Application no: H17-0499-15

Description: Proposed two storey extension.

Location: 4 LOW GATE
SURFLEET
SPALDING
PE11 4AS

ACKNOWLEDGEMENT OF AMENDMENT

Scale	Date	
1:50&1:100@A1	June 2015	
Ref.	Number	Rev.
2205	A_3103	B

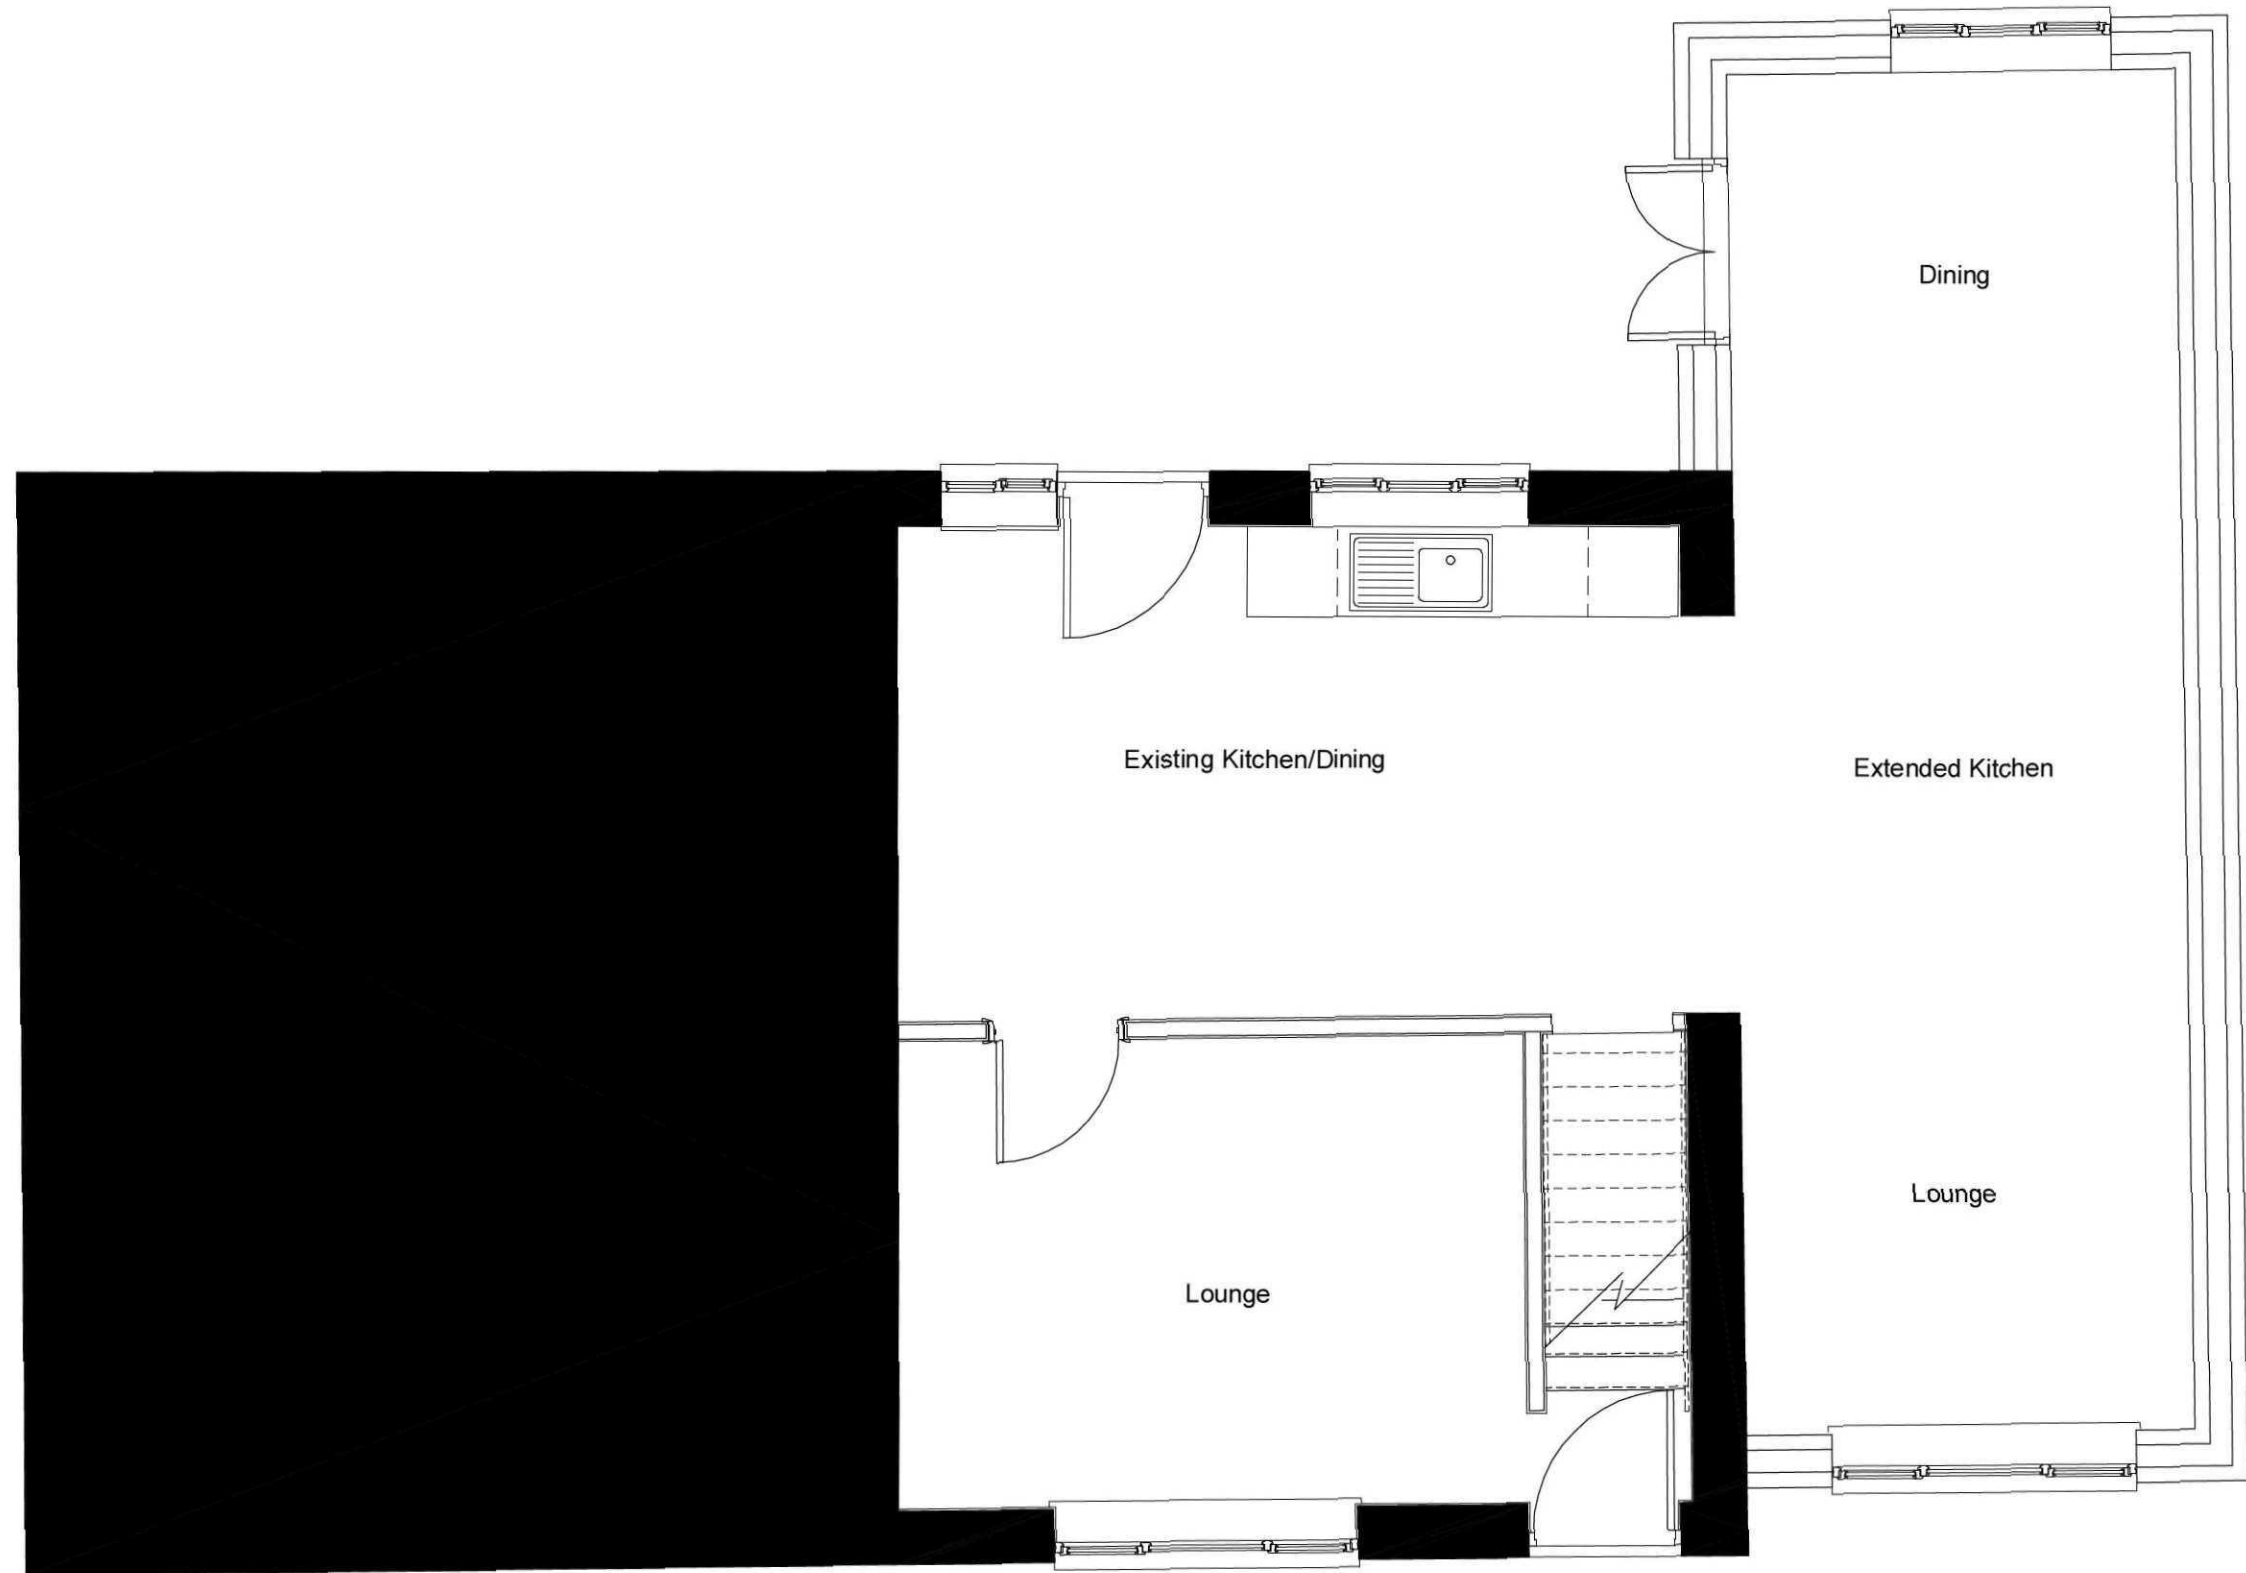
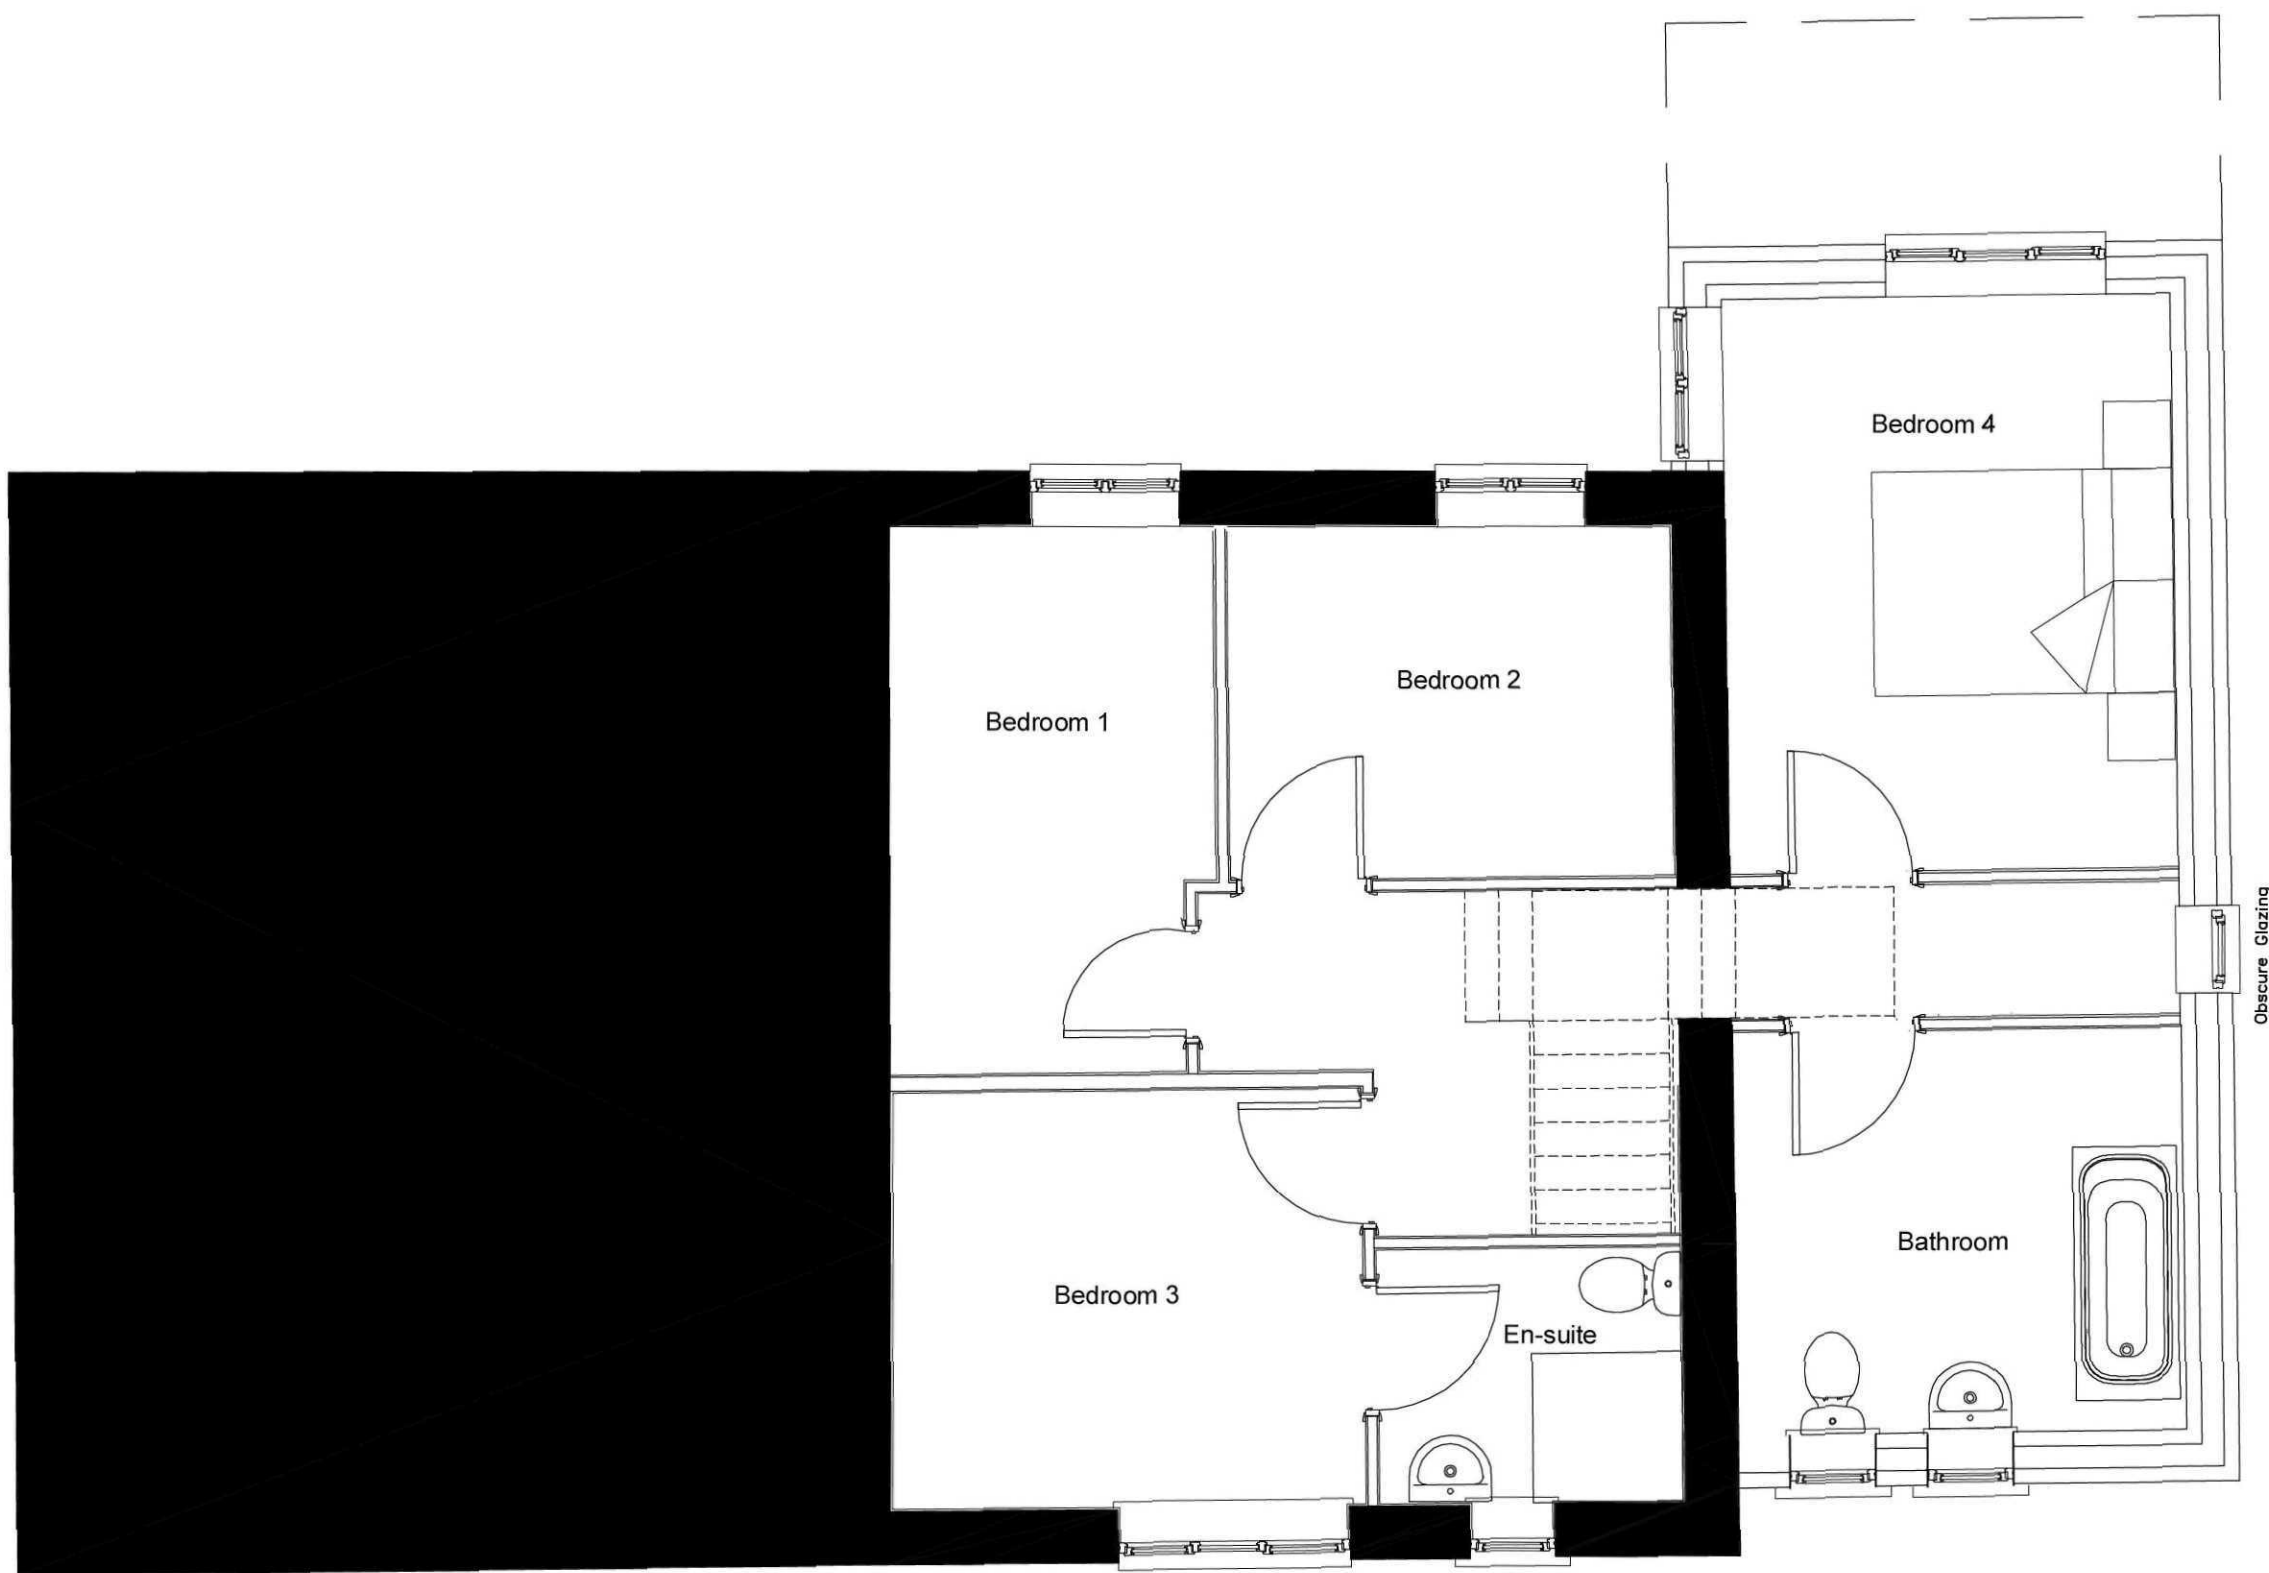
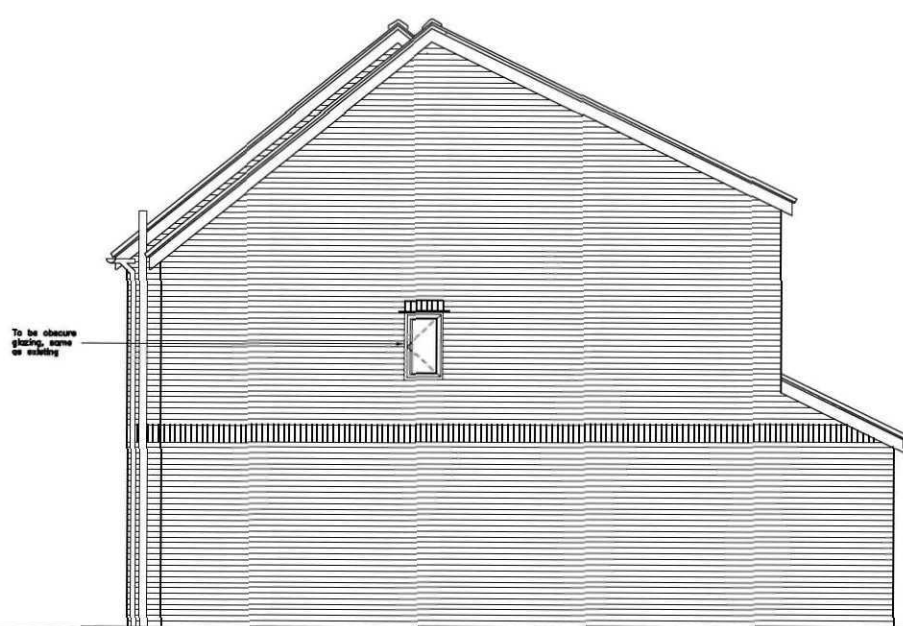
Amendment: Reduce two-storey extension from 3 metres to 1.5 metres
and label the hallway as obscure glazed

- To label the hallway as obscure glazed
- To reduce the two storey extension where it projects to the rear from 3 metres to 1.5 metres
